CITY OF ALBUQUERQUE

Re: PNM Mesa del Sol Substation Grading Plan
Engineer's Stamp dated 2-9-07 (R16/D002B)

Based upon the information provided in your submittal received 2-12-07, the above referenced plan is approved for Site Development Plan for Building Permit action by the DRB.

GRADING AND DRAINAGE PLAN:

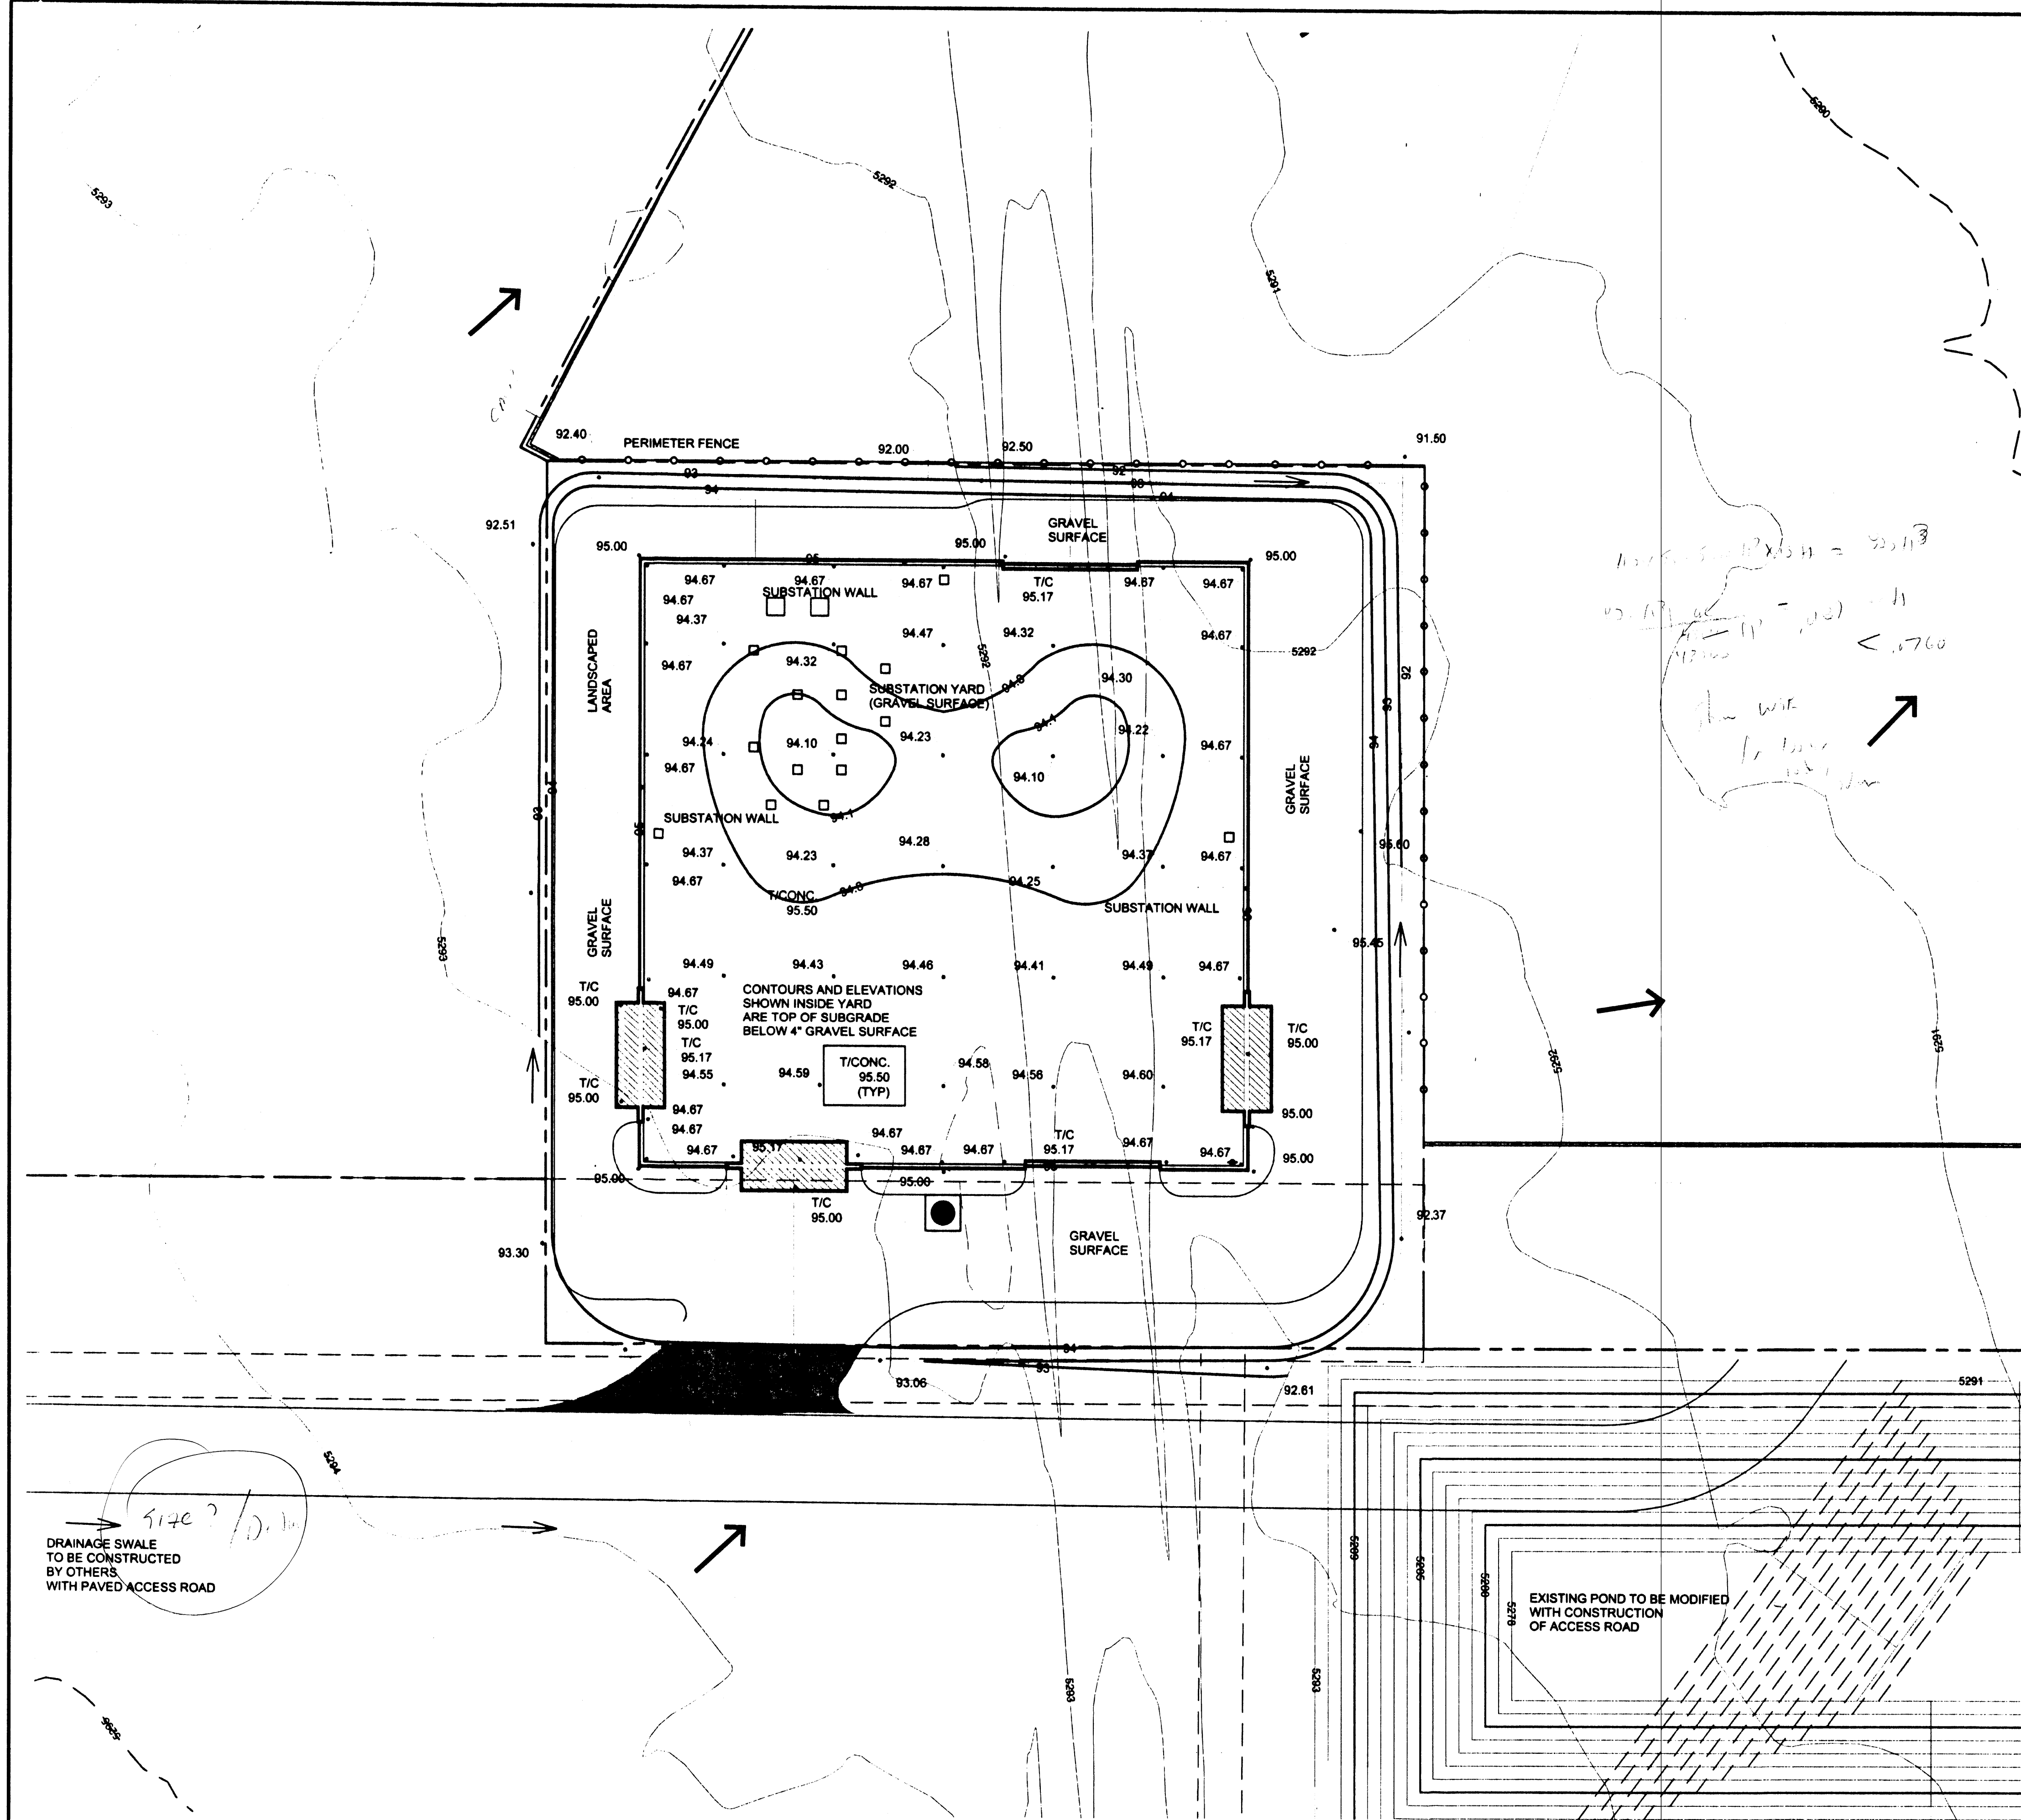
- Provide the ponding volume provided and the water surface elevation inside the enclosure for the 100 yr-10 day storm.
- Provide more detail for the swale on the west side of the road and the modifications to the retention pond.
